This is yet another variation to HH original application.

status: PLANNING
 project: MERCHANTS FIELD CLECKHEATON
 site: SITE LAYOUT
 drawn: QYRB. date: MAY 2019
 checked: RB. scale: @ A0:1:500
 job no: 122. dsg no: 122-PL-01-V

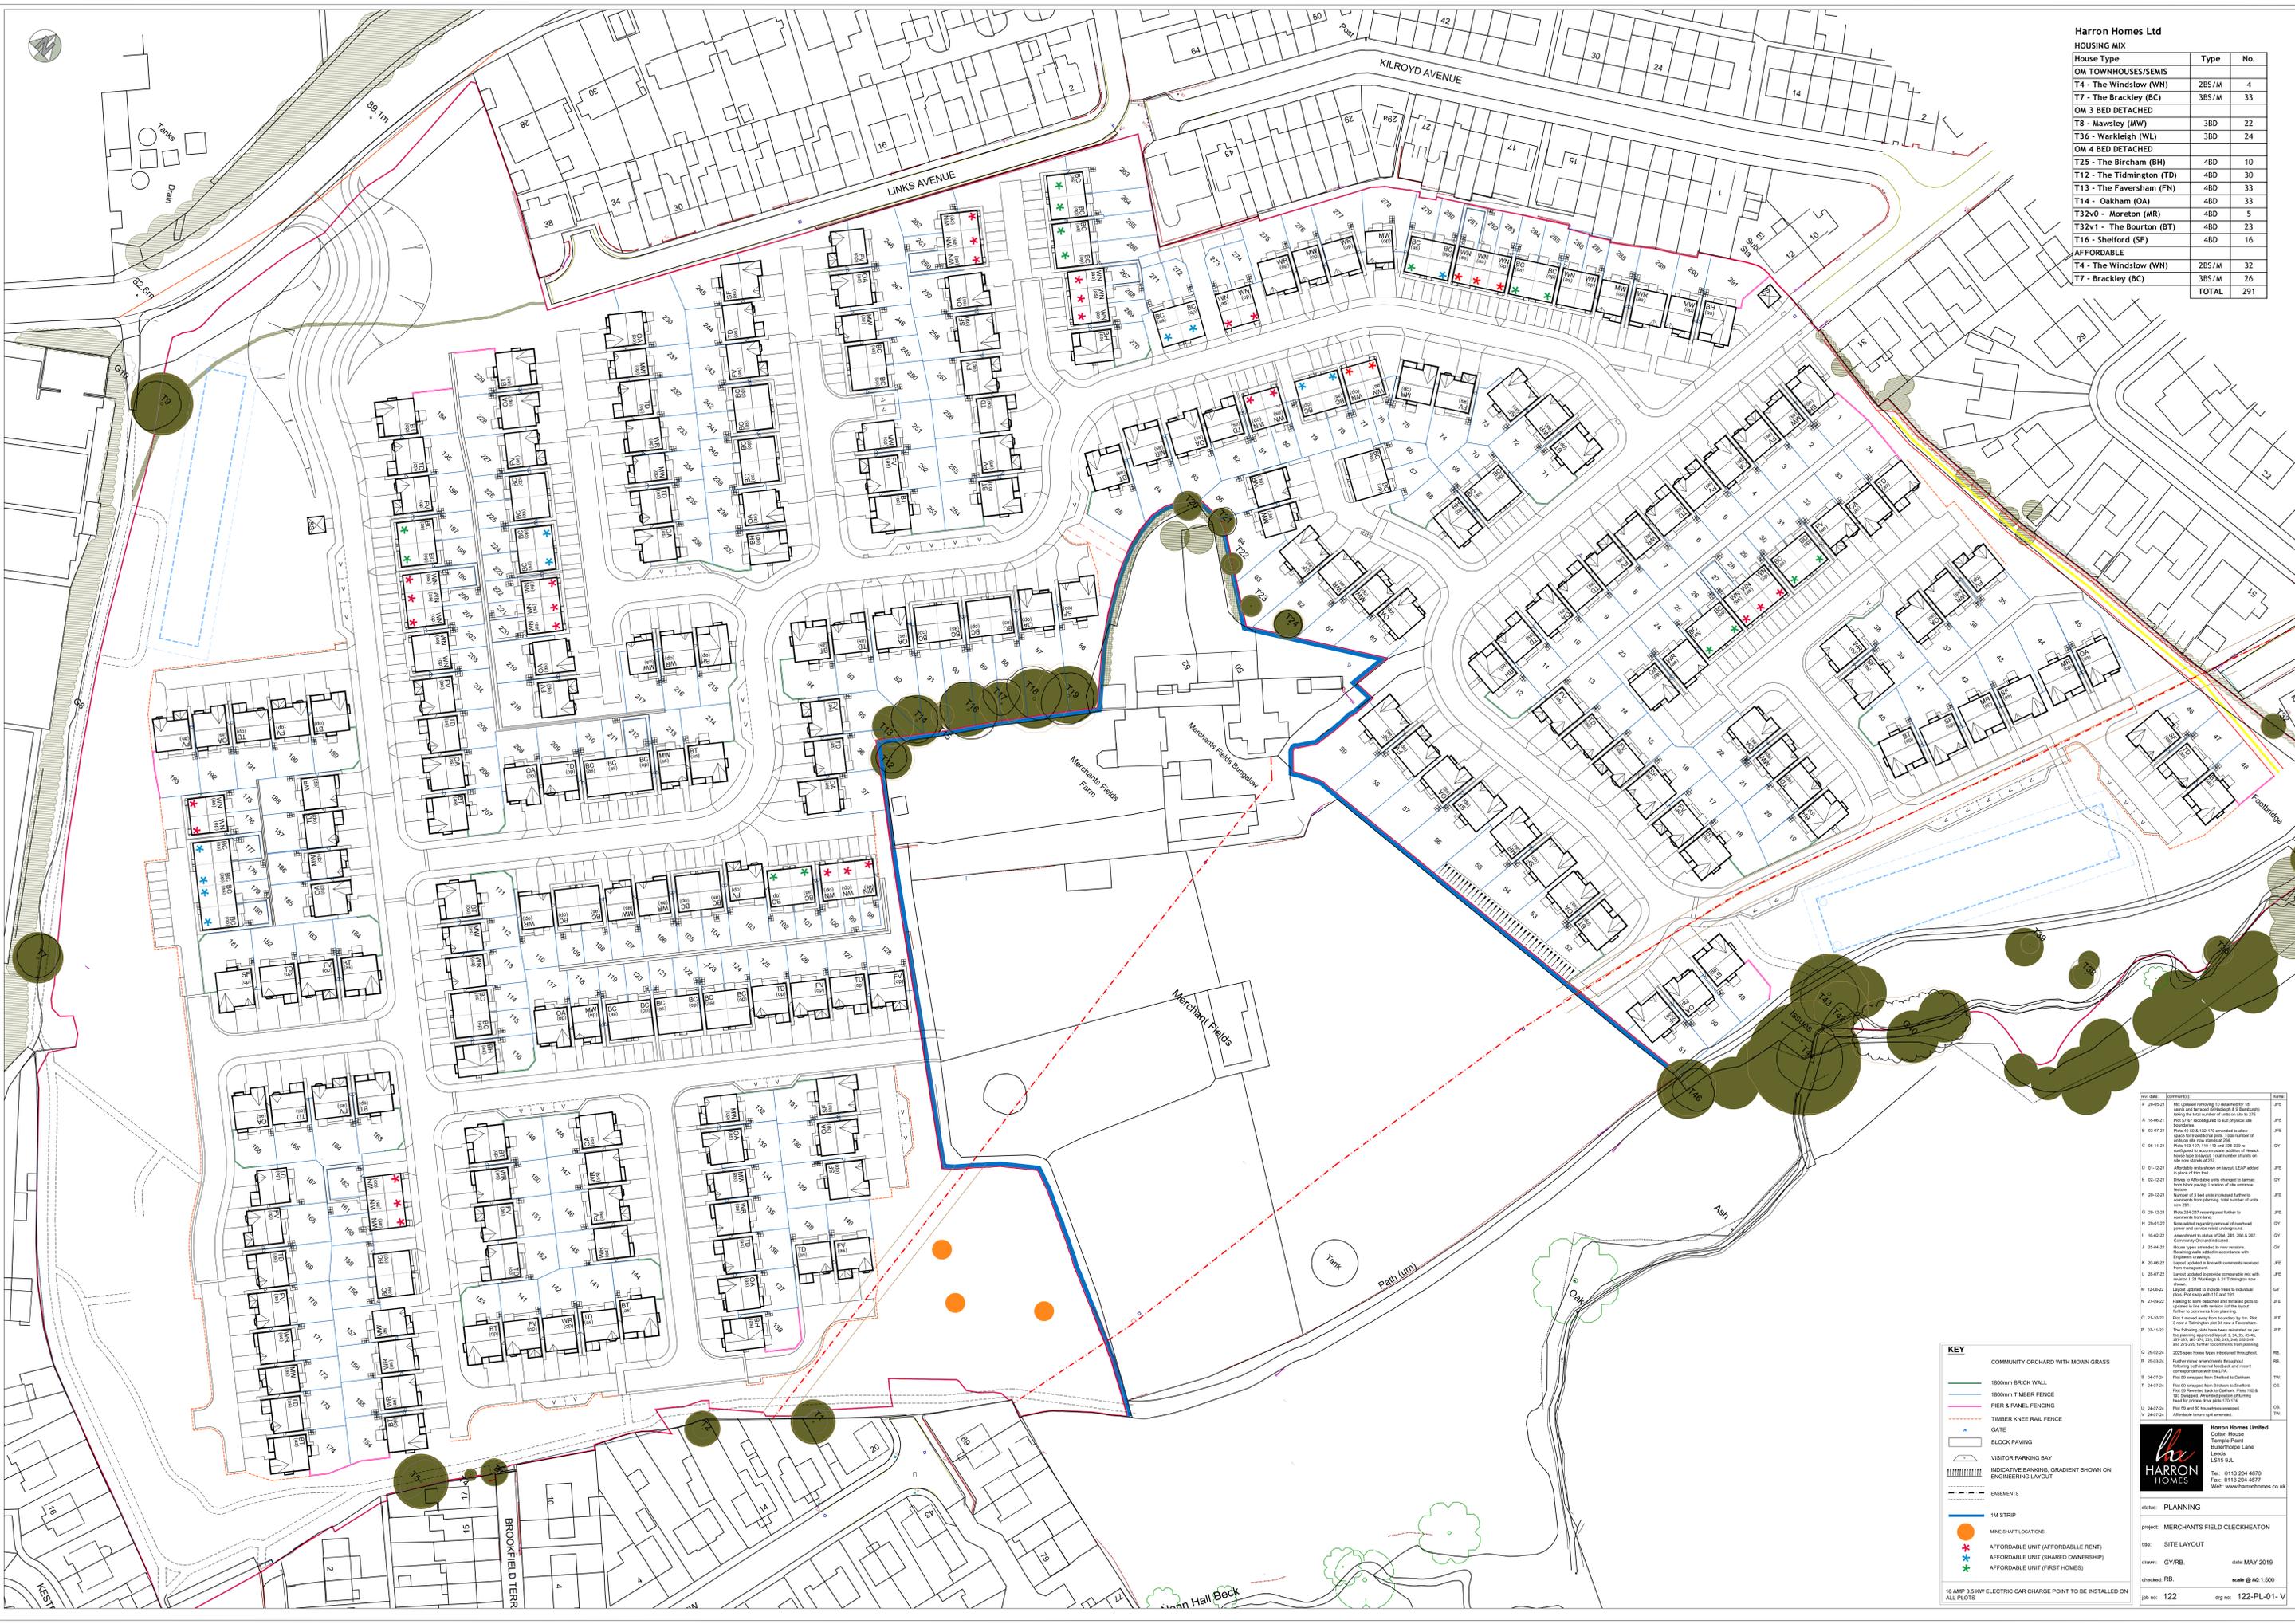
The traffic Queue's on Hunsworth Lane tail back to the A638 Bradford road! this estate of houses will be used as a short cut from the entrance on Hunsworth Lane to Kilroyd and Kilroyd to Hunsworth Lane for hundreds of drivers at peak times of the day despite traffic calming measures, this is a critical road safety concern.

I am unable to fully understand the plans! as the key provided does not seem to be accurate as to lines and colours on the plans, some house types on the plans are not in the key plan, I would like clarification as to the provision of Cycle paths and Cycle lanes as per the planning office commitment for safer roads and better living environments.

Again I would like to point out the problem of the forseen RAT RUN between Hunsworth Lane and the A58 through Kilroyd Drive, and the possibility of accidents and Deaths.
